Our Ref: R/259/18/HH
Your Ref:

Town & Country Planning Act 1990 (as amended)
Town & country Planning (Development Management Procedure) (England) Order 2015
Application for Planning Permission for Works or Extension to a Dwelling

Development 2 No. dormer windows to north elevation, 2 No. rooflights to south elevation, 1 No. rooflight to east elevation & 1 No. rooflight to west elevation. This application may affect the setting of a listed building.

Location The Rodings Station Road Rustington

Site Plan
(Scale 1:1250)

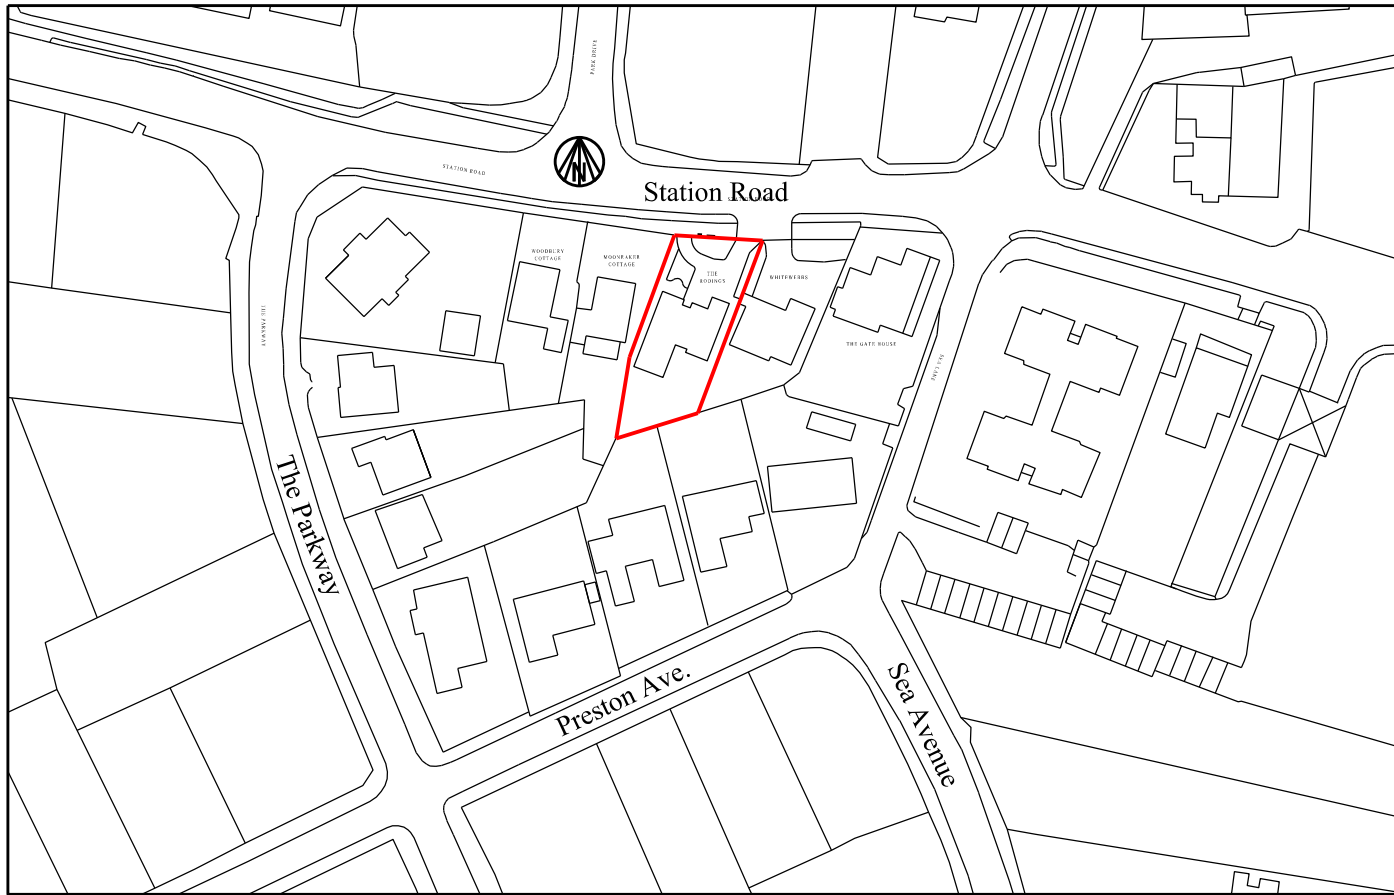
Location Plan Amend

Please red edge the application site.
